From: Maria O'Donnell <MODonnell@cityofsydney.nsw.gov.au>
Sent: Friday, 2 March 2018 2:28 PM
To: Michelle Niles
Subject: Notice of Modification Request for Block 4S, Central Park, Chippendale (SSD 5700 MOD 2) - City's response

I refer to your email correspondence dated 20 February 2018 and notification of the above mentioned modification to the approved State Significant Development application. It is understood that the proposed modification relates to deletion of planter boxes located in the through-site link between Block 4S and Block 4N, in order to provide access and ventilation to a High Voltage Cable Chamber room servicing Block 4N.

GROUND & LEVEL 00 PLAN

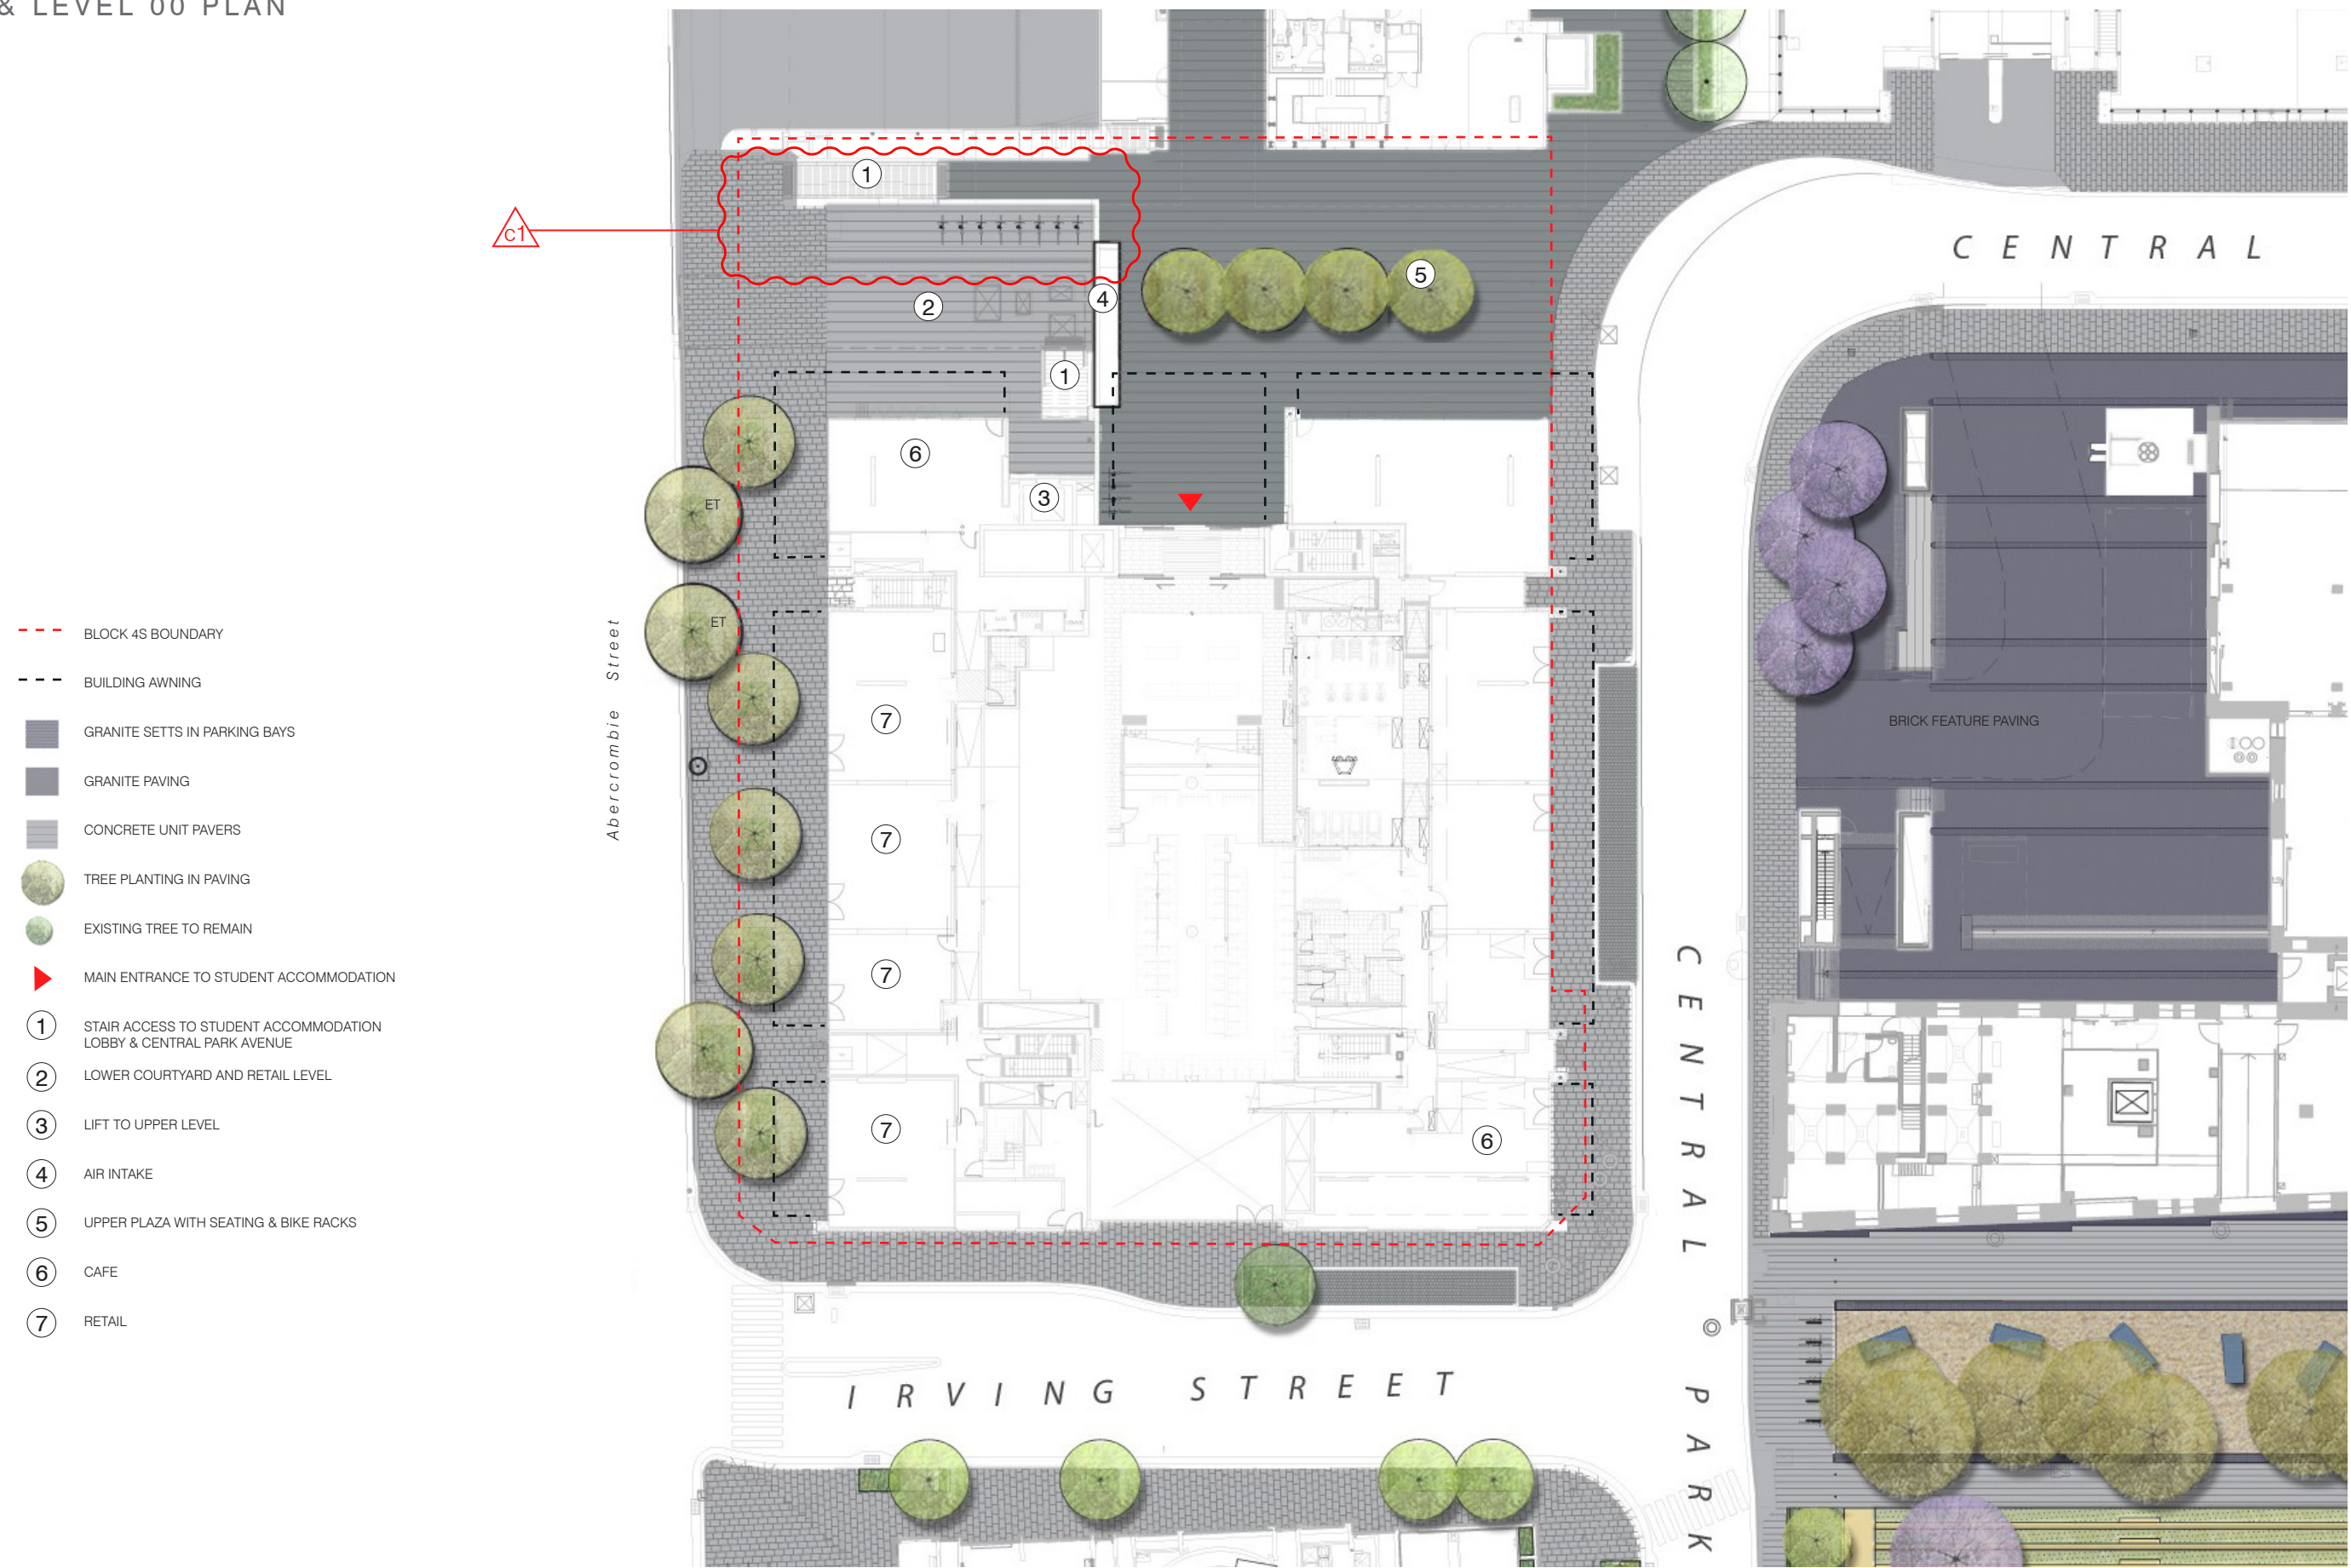
The city has reviewed the documentation submitted with the proposal. The SEE and plans provided are conflicted with respect to what exactly is proposed by the modification. The Department are encouraged to ensure that the most up to date approved landscaping plans are used to identify the location of trees in the area. It is noted that Condition B25 of SS 5700 that relates to landscaping of the site was approved by Council on 22 August 2014.

It is the City's preference to retain all approved trees in that area as the planting offers wind mitigation as well as shading within the pedestrian thoroughfare. The Department are encouraged to require the applicant to carry out further investigations to re-route the blue hatched egress area so that the planting can be retained given its significant contribution to pedestrian amenity in the area.
